Reference no. 2024/CL/92111/W

Site Address	land opp, 104, Wakefield Road, Lepton, Huddersfield, HD8 0EA
---------------------	---

Description	Prior notification for change of use from agricultural building to one dwelling
--------------------	--

DECISION - REFUSED

Drawing Title:
Ground Floor Plan
As Existing

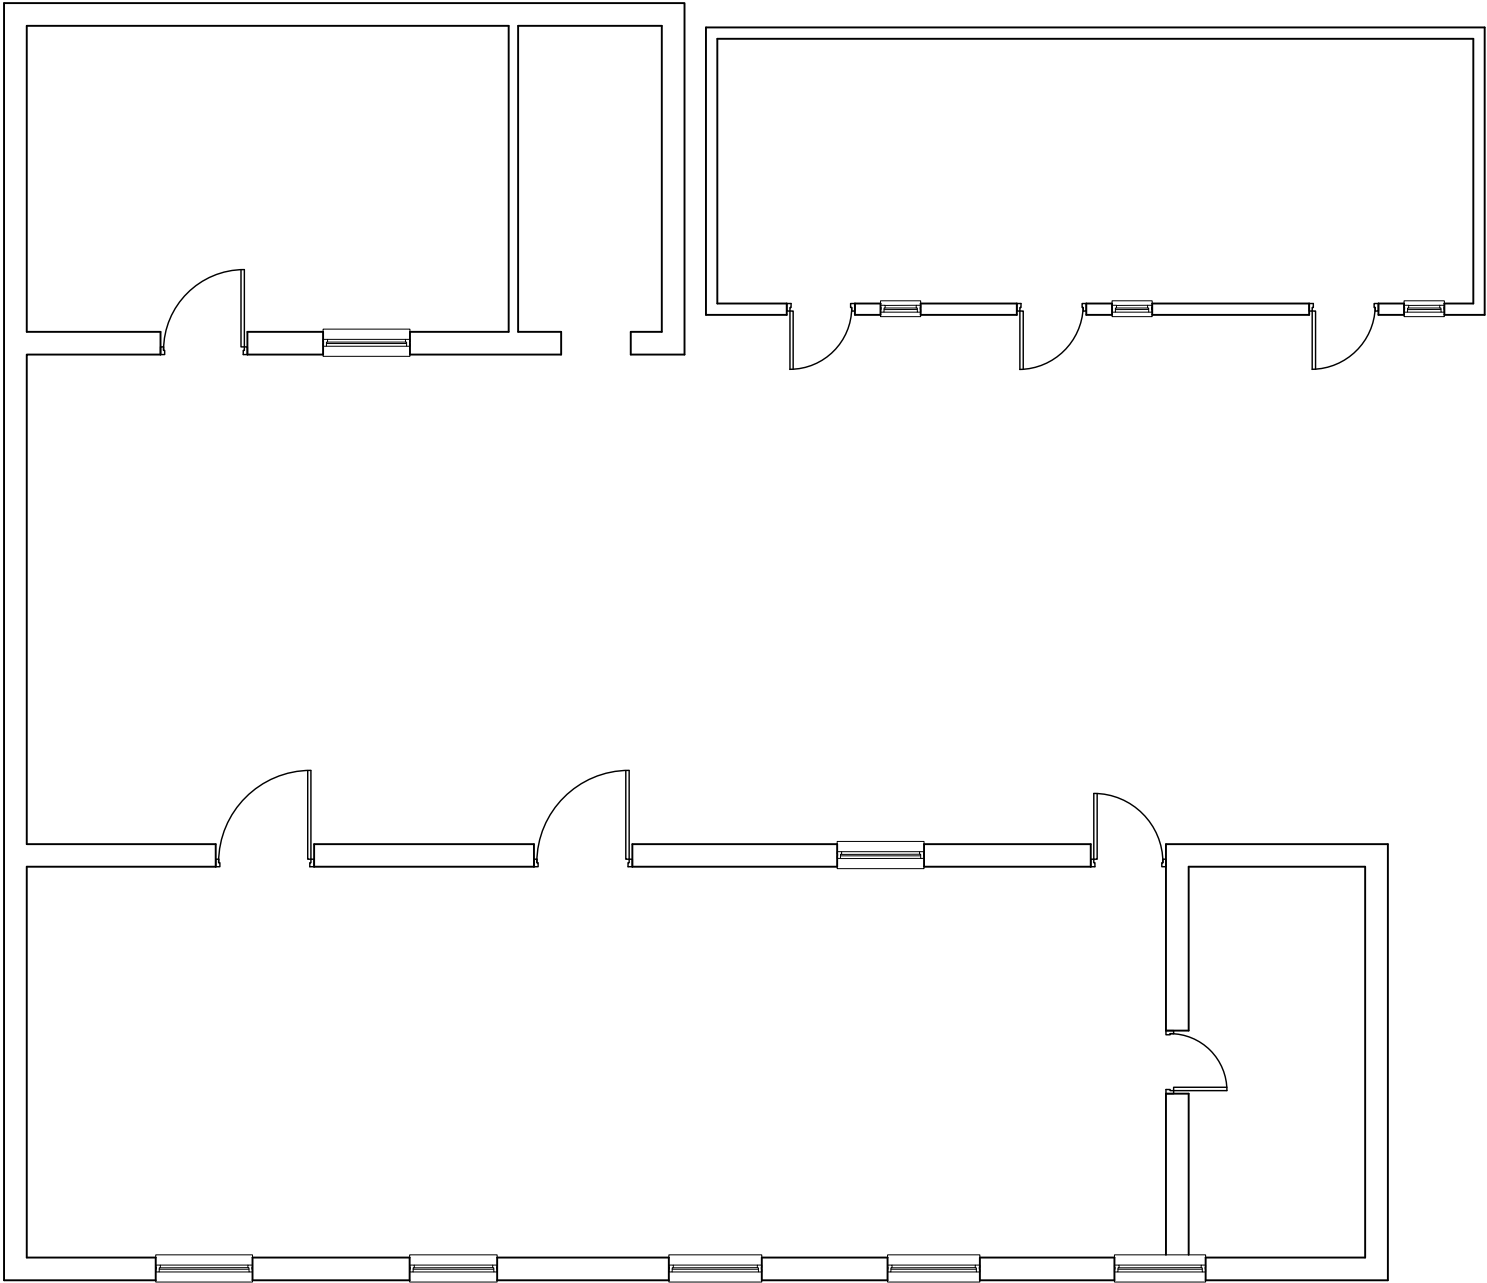
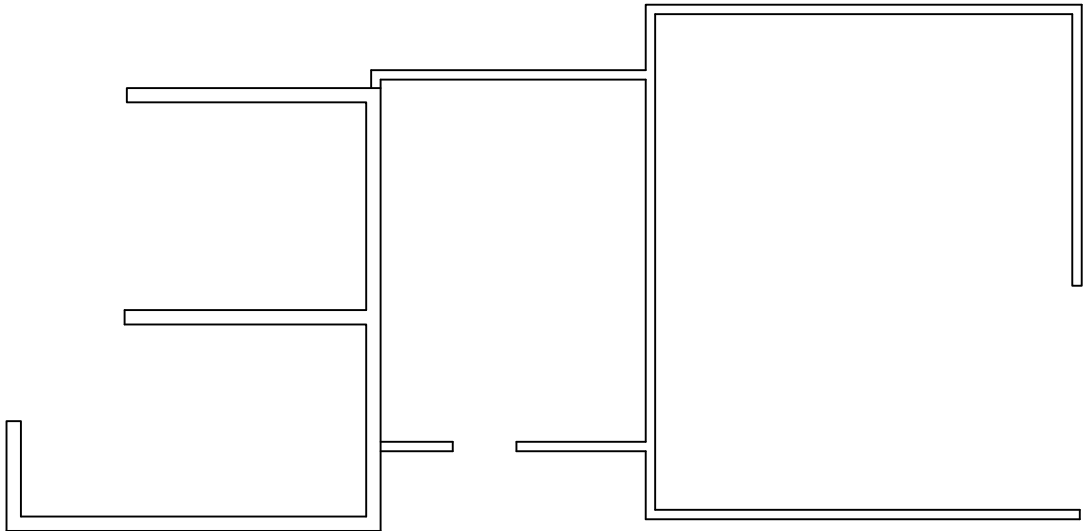
As a result of an officer site visit, officers note that the existing structures to be converted for a garage and store are wooden and appear to be light weight in their construction style. Despite requested to do so, the applicant has not provided evidence of the garage/store structural capabilities or the materials

the proposed conversion would consist off. However, the plans indicate the thin timber clad walls are to be replaced with unspecified thicker material which would appear to be complete replacement of the existing structure. Consequently, and has the Local Planning Authority has no evidence to demonstrate otherwise it is considered the works to form garage and store go beyond development that could amount to conversions and as a matter of fact and degree, amount to a rebuilt of the existing light weight timber boarded structure.

The applicant has not provided information relating to the northern building or link extension between the southern and northern building. The materials list on the existing elevation plan omit to specify the walling materials for the north

building although it appears this building is of light weight construction which would require significant structural works and rebuilding for it to be suitable for conversion. The steel profile sheet covering between the north and south building also appears to be removed leaving only the west flank wall for the link extension to the built. It is considered the works required to the north building and link extension would amount to a rebuilt of these structures.

Drawing Title:
Ground Floor Plan
As Proposed
Scale: Date: Drawn: Checked:
1:100 @ A3 May 24 TC
Drawing Number: Revision:
006

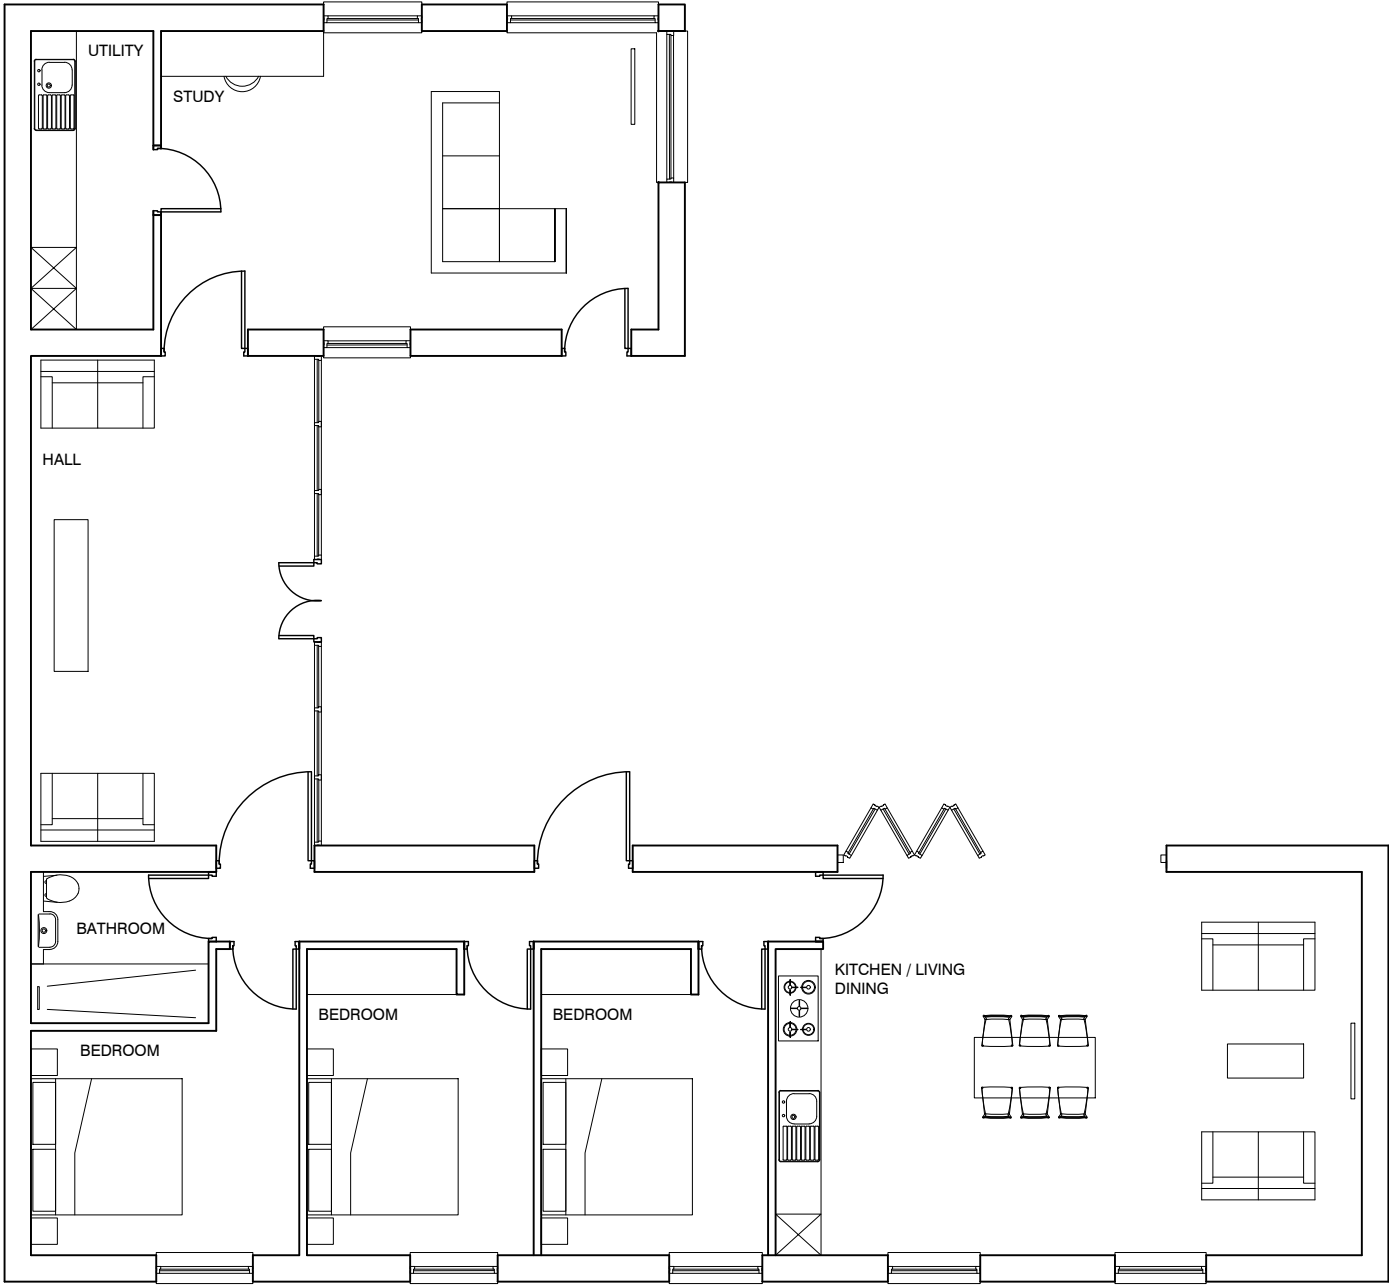
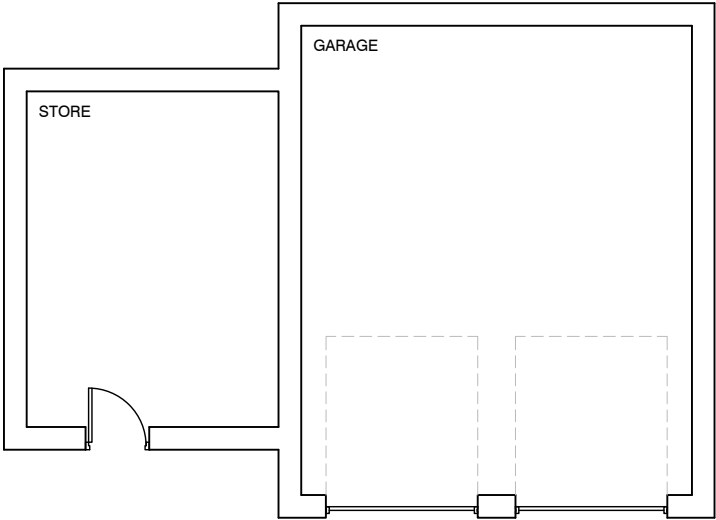
(c) the floor space of any dwellinghouse developed under Class Q having a use falling within Class C3 (dwellinghouses) of Schedule 1 to the Use Classes Order exceeds 150 square metres,	Fail: The garage store is considered to be a domestic adjunct to the primary living areas all falling within Class C3 and totalling a combined floor area of 200 sq. metres. Consequently, the proposed works to form a dwellinghouse, including the link extension and proposed garage/store, falling within Class C3 would exceed 150 sq. metres.

(h) the development would result in the external dimensions of the building extending beyond the external dimensions of the existing building at any given point, other than- (i) extension of the building allowed by paragraph Q.1(i) (ii) protrusions of up to 0.2 metres to accommodate building operations allowed by paragraph Q.1(j)(i);	Fail: The proposed and existing elevations indicate parts to the roof of the existing structure will be raised, particularly the northern building and the red brick wall forming the link between the southern and northern building. The raising of the roof exceeds 0.2 metres.

(i) the development under Class Q(b) would result in an extension that – (i) has more than one storey, (ii) is sited anywhere other than to the rear of the existing building (iii) extends beyond the rear wall of the existing building by more than 4 metres,	The existing and proposed plans indicate an existing profiled sheet roof covering an area between the southern and northern building is to be removed and replaced with a link extension between the two buildings.

1. The proposed alterations to the design and structure of the buildings would be so extensive to be within the reasonable definition of “conversion”. The proposed development therefore does not benefit from permitted development rights under the provisions of Part 3, Class Q of Schedule 2 of the Town and Country Planning (General Permitted Development) (England) Order 2015 (as amended).

1. The proposed change of use would result in a new dwellinghouse, including the proposed domestic garage/store, exceeding 150 square metres contrary to sub-paragraph Q.1(c) of Part 3, Class Q, Schedule 2 of the Town and Country Planning (General Permitted Development) (England) Order 2015 (as amended).

2. The external dimensions of the proposed building would, in places, extend 0.2 metres beyond the external dimensions of the existing building contrary to sub-paragraph Q.1(h) of Part 3, Class Q, Schedule 2 of the Town and Country Planning (General Permitted Development) (England) Order 2015 (as amended).
